From: [Rodenbeck, Jay B.](#)
To: [Aranda, James M.](#)
Cc: [Webb, Robert L.](#)
Subject: FW: Transportation Comments for ABQ Uptown (PR-2022-006664)
Date: Friday, July 1, 2022 11:26:00 AM

From: Rodenbeck, Jay B. <jrodenbeck@cabq.gov>
Sent: Friday, July 1, 2022 10:03 AM
To: peterbutterfield@Q.com
Cc: Al-najjar, Marwa G. <malnajjar@cabq.gov>; Armijo, Ernest M. <earmijo@cabq.gov>; Grush, Matthew P. <mgrush@cabq.gov>
Subject: Transportation Comments for ABQ Uptown (PR-2022-006664)

I am checking in with you this morning regarding your Administrative Amendment at ABQ Uptown (PR-2022-006664) currently being reviewed. Transportation sent you comments on June 7 including keeping signage out of the City ROW. Ms. Wolfenbarger from Transportation informed me that you acknowledged her comments but never addressed her comment(s). Ms. Wolfenbarger's last day with the City was last week so perhaps you responded to her after she had left. Could you please confirm your response to Ms. Wolfenbarger's comments on your Administrative Amendment if you already responded. If you haven't prepared a supplemental submittal in response, please confirm that as well. I have copied our current Transportation t

SHEET :  
A101

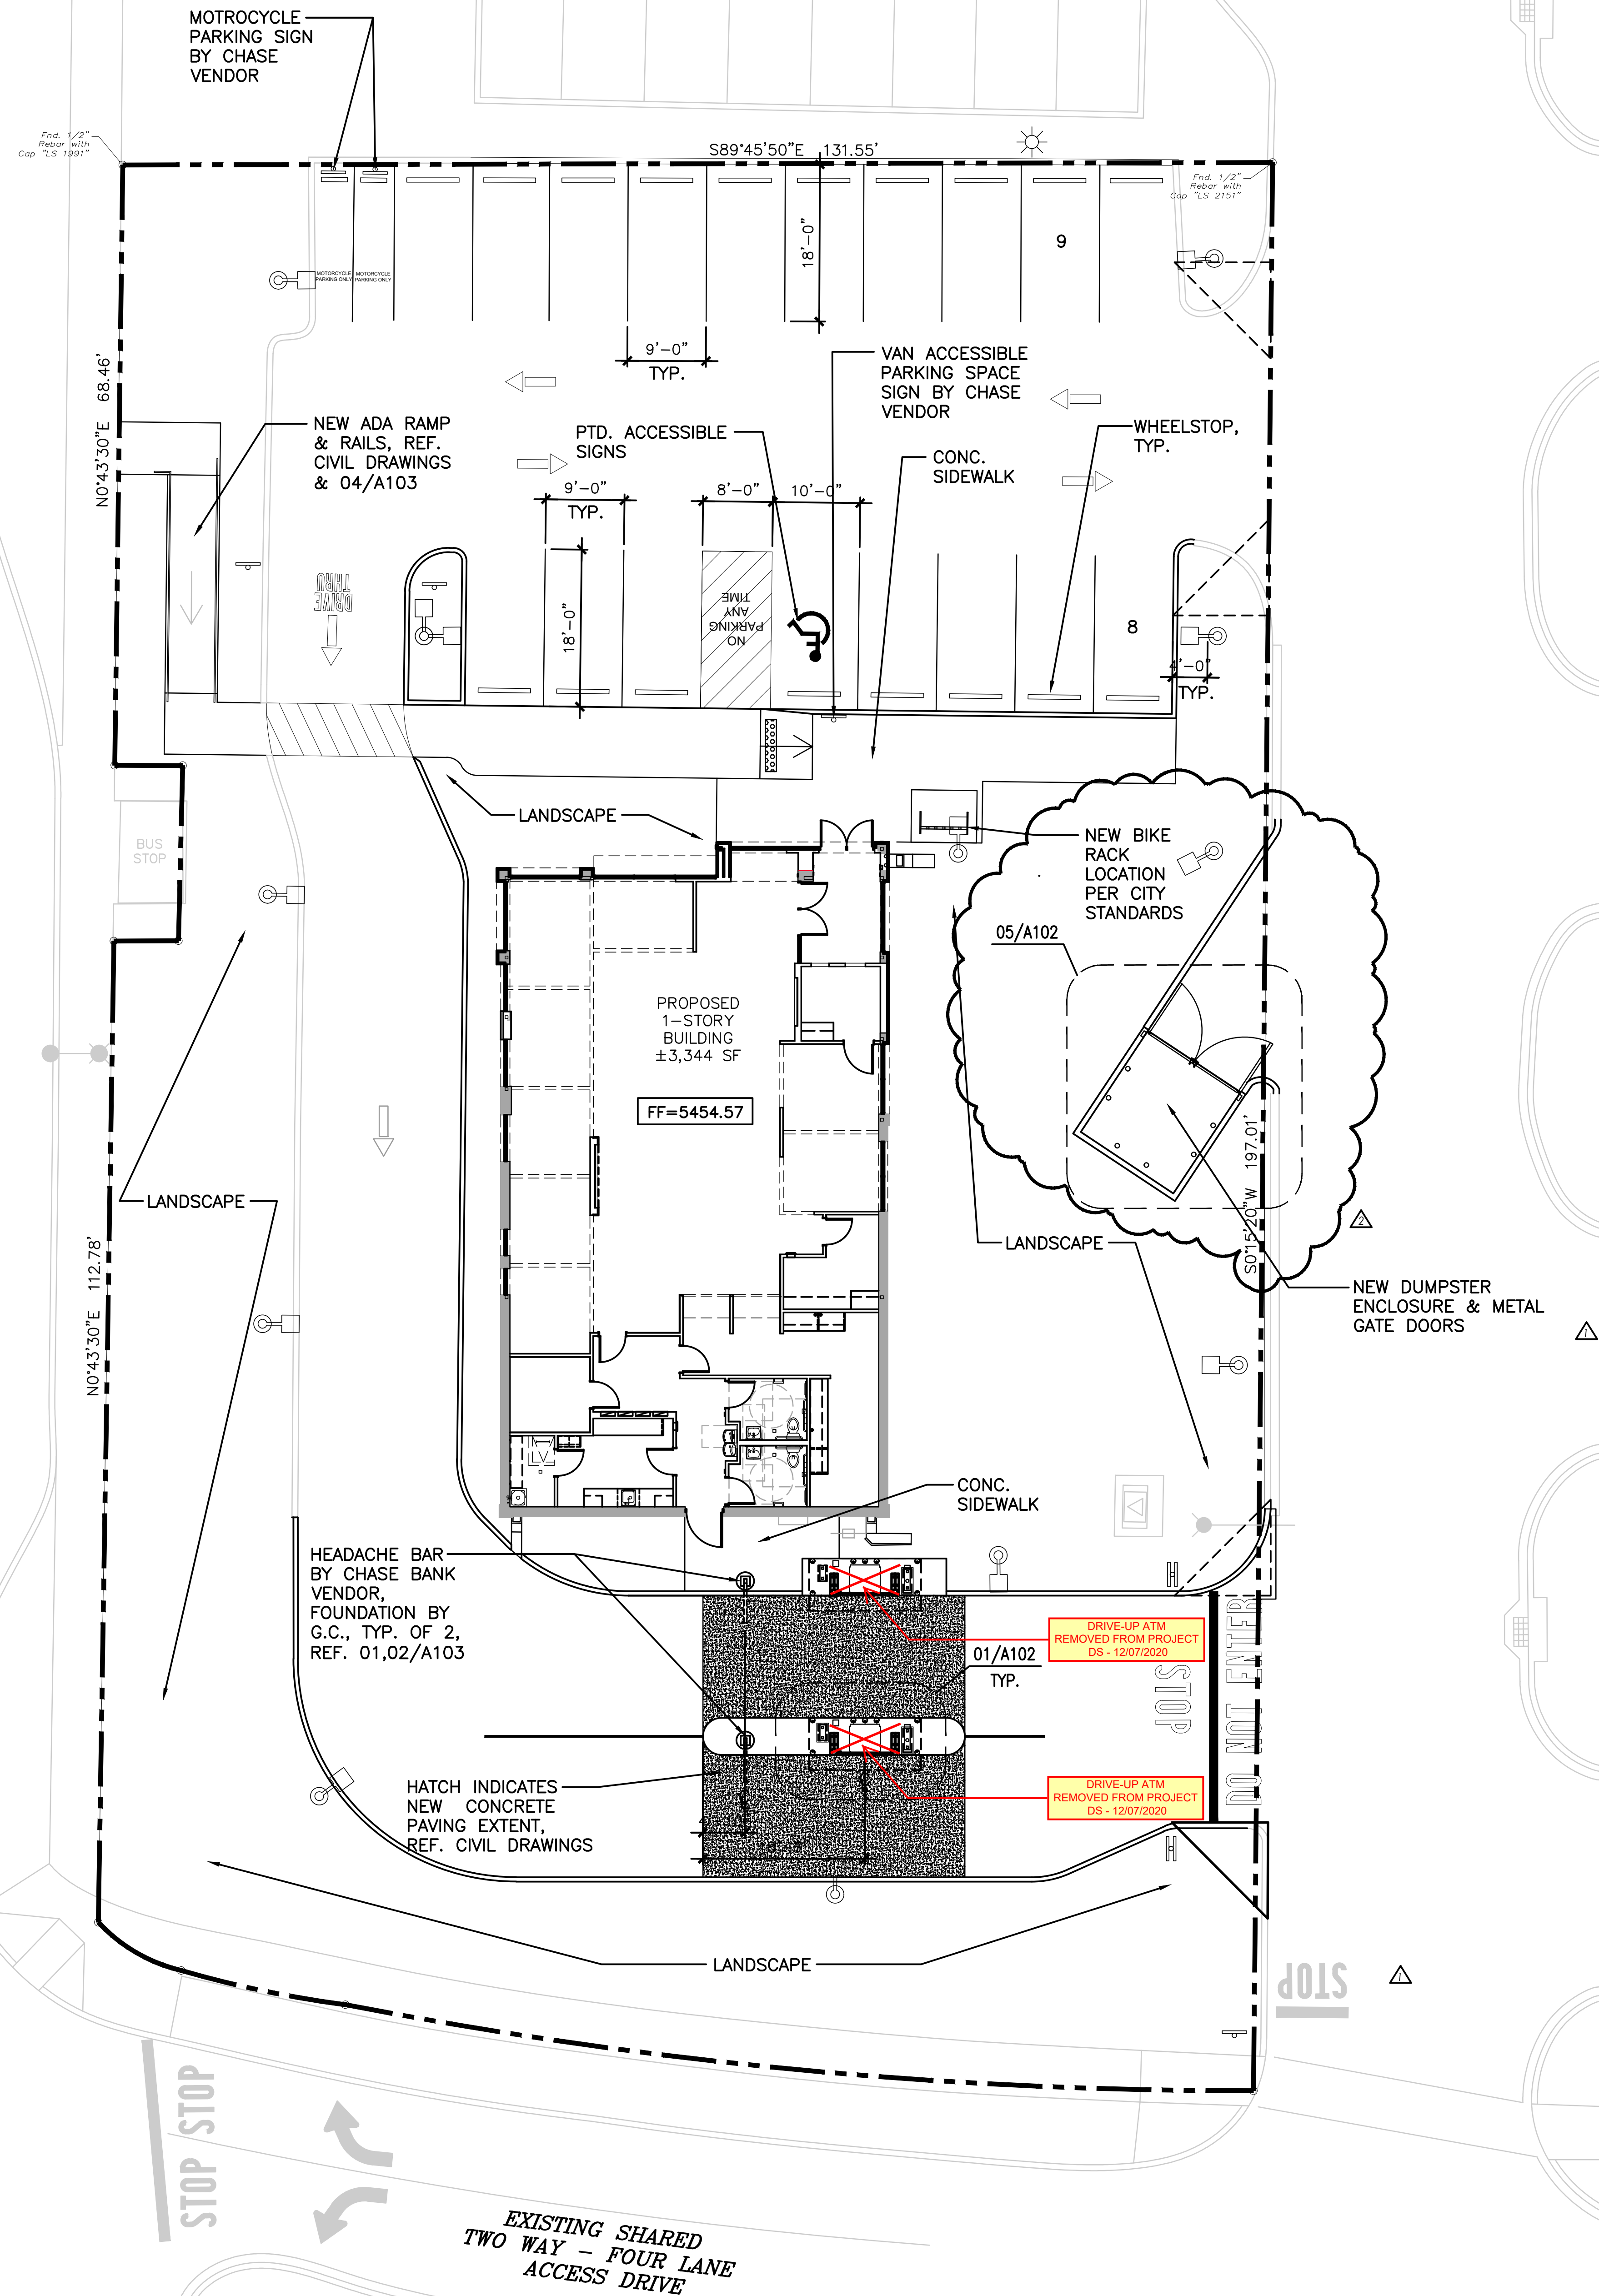
Please add the following note on the site plan "NO private structures and/or Signs will be located within Public Right of Way"

The client has decided to remove the sign that is in the right-of-way. I have not prepared a supplemental submittal. Is this something I should do prior to receiving all the comments?
